Recommendation Report for Planning Permission for Works or Extension to a Dwelling

REF NO: BR/152/21/HH

LOCATION: 38 Ash Grove
Bognor Regis
PO22 9JH

PROPOSAL: Loft conversion with 2 x dormers

PROPOSED SECOND FLOOR PLAN

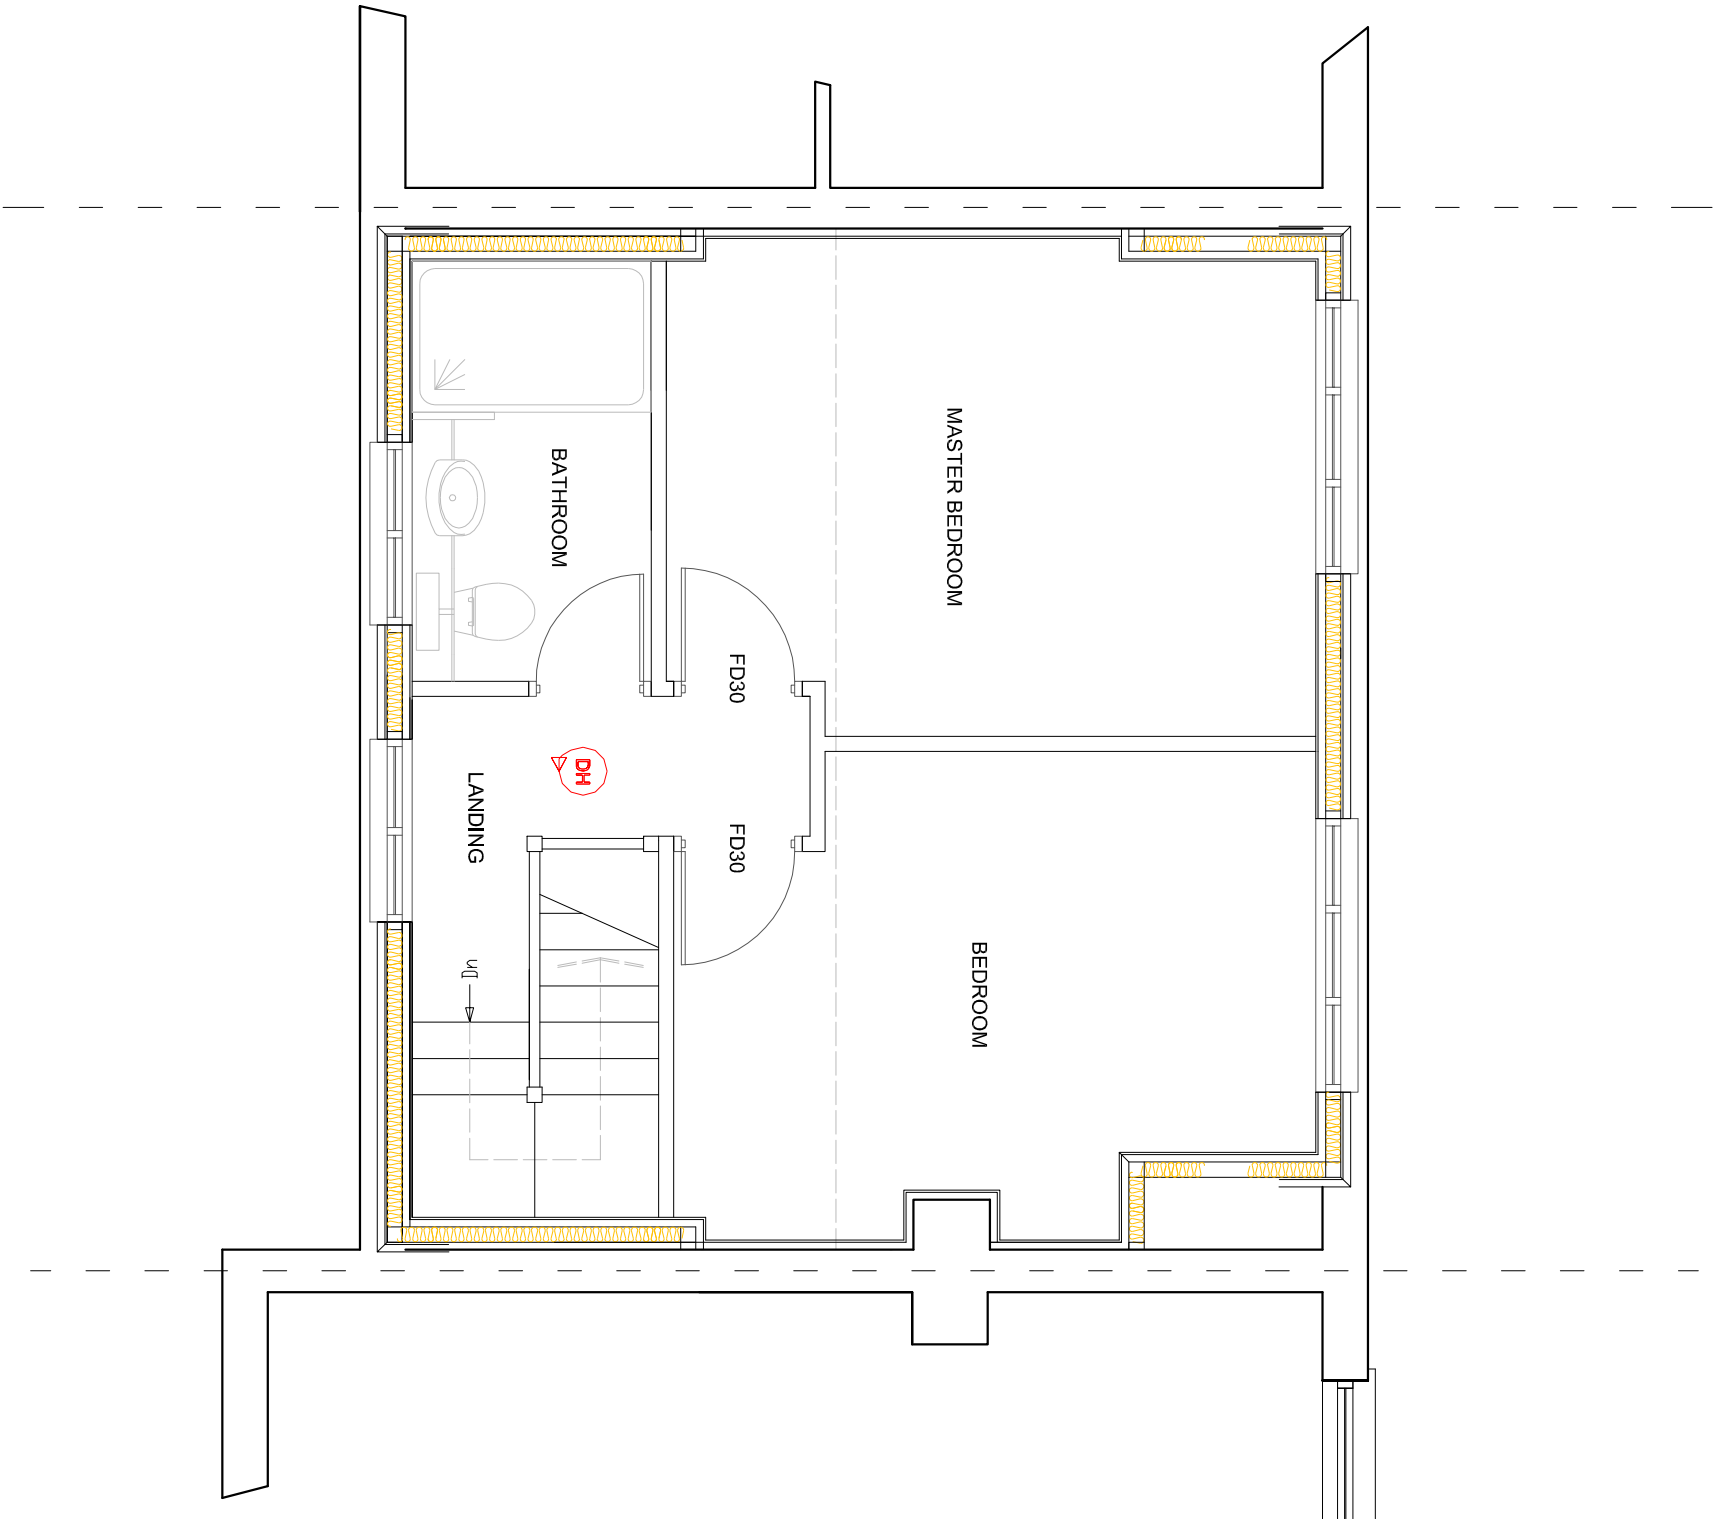
The proposals are for a loft conversion with two dormer windows to front (east) and rear (west) roof elevations. Due to the siting at front of property the dormer will be highly visible from the street scene, the proposed dormers are a large addition to front (east) roof elevation and as such are not in-keeping with existing property or character of area so do not comply with policy D DM1 of the Arun Local Plan.

Due to the large scale, size and flat-roofed-box-shaped design of proposed dormers they are not visually integrated with the existing building and cause adverse harm to character of area so do not comply with policy D DM1 and D DM4 of the Arun Local Plan.

PROPOSED ELEVATIONS

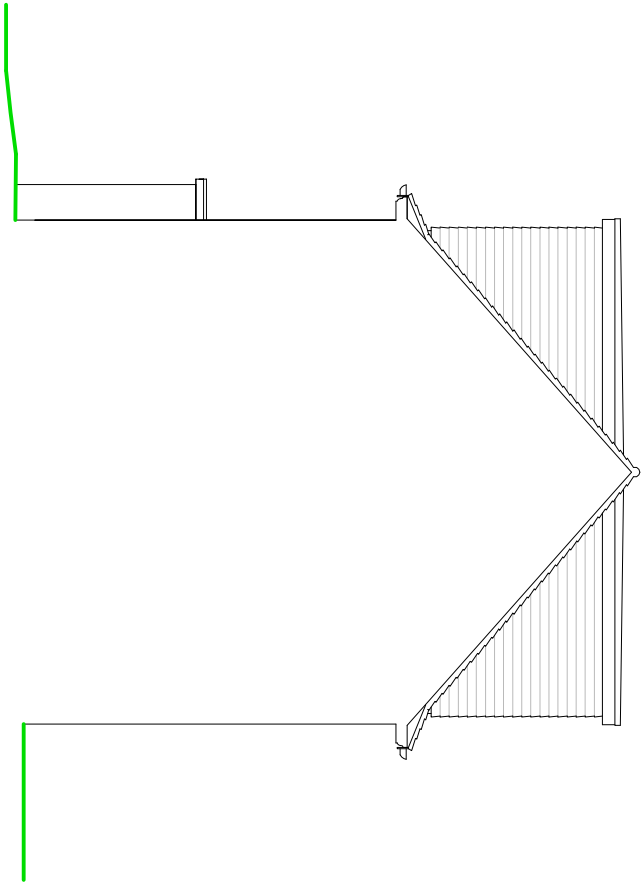
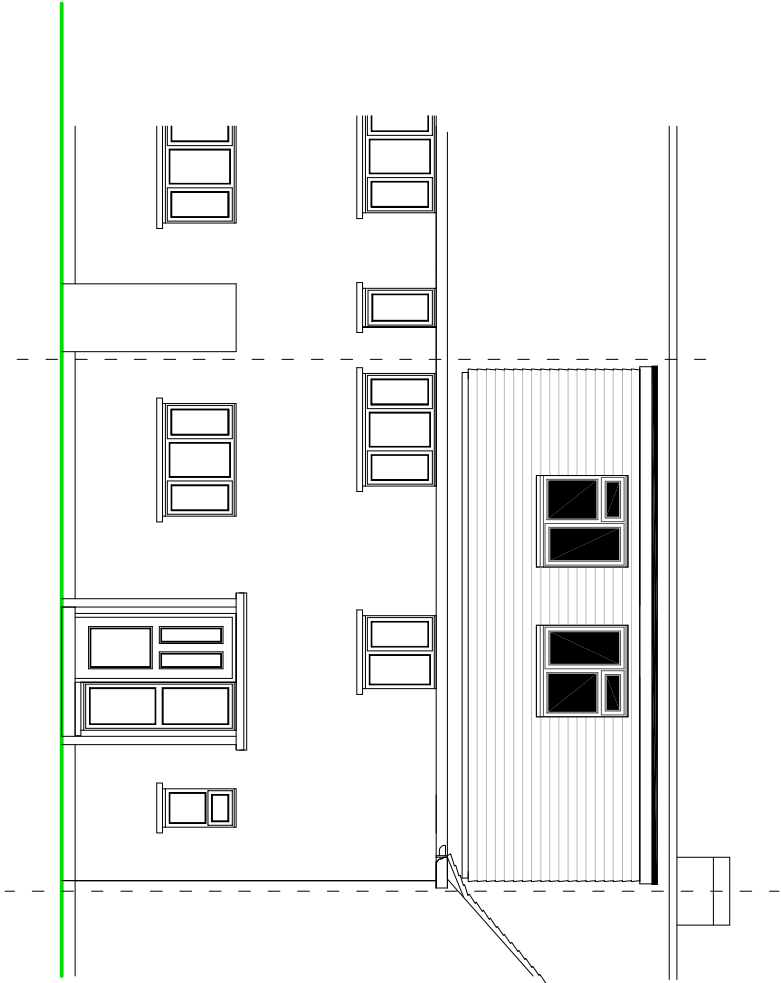
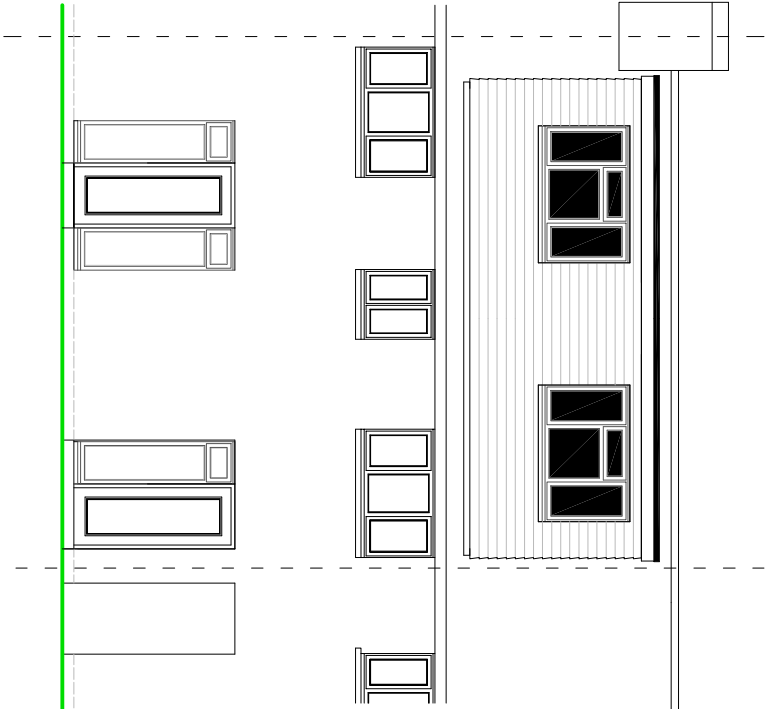
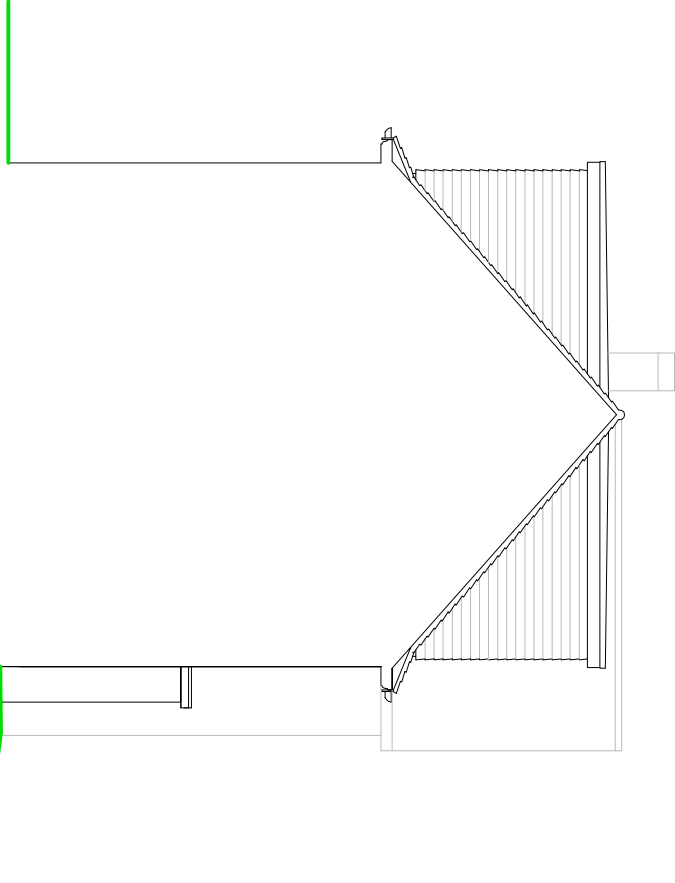
The proposed front (east) dormers will have a width of approximately 6.85m and a depth of approximately 3.10m. The height to flat roof will be approximately 2.54m.

The proposed rear (west) dormers are less visible from street scene so do not adversely impact surrounding character of area. However they do not sympathetically relate to and are not visually integrated with, the existing building in massing, design and scale so do not comply. Such a dormer may be possible under permitted development.

The proposed rear (west) dormers will have a width of 6.46m and a depth of approximately 3.10m. The height to flat roof will be approximately 2.54m. Due to the

Due to scale and size of the proposed development it will cause adverse harm to appearance of street scene and character of surrounding area so it does not comply with Policy D DM1 and D DM4 of the Arun Local Plan.

The proposed front (east) dormers will have a width of approximately 6.85m and a depth of approximately 3.10m. The height to flat roof will be approximately 2.54m. Due to siting at front (east) of dwelling there is increased risk to overshadowing or overbearing effects to neighbouring properties to north and south. Due to large bulk and scale of the dormers there is adverse harm caused to overshadowing or overbearing effects to neighbouring properties number to 40 Ash Grove to north and 36 Ash Grove to south so this does not comply.

The proposed rear (west) dormers will have a width of 6.46m and a depth of approximately 3.10m. The height to flat roof will be approximately 2.54m. Due to siting at rear (west) of property there is increase risk to overshadowing or overbearing effect to rear of properties to north and south. Due to the small distance to north and southern ends of property roof there will be some small adverse impact to overshadowing or overbearing effect to neighbouring properties number to 40 Ash Grove to north and 36 Ash Grove however not to an extent to warrant refusal.

- 1 The dormer window to the front by reason of its size and position is not in-keeping with the dwelling or character of the surrounding area so causing adverse harm to the character of the surrounding area in conflict with policy D DM1 and D DM4 of the Arun Local Plan and Section M of the Arun Design Guide.
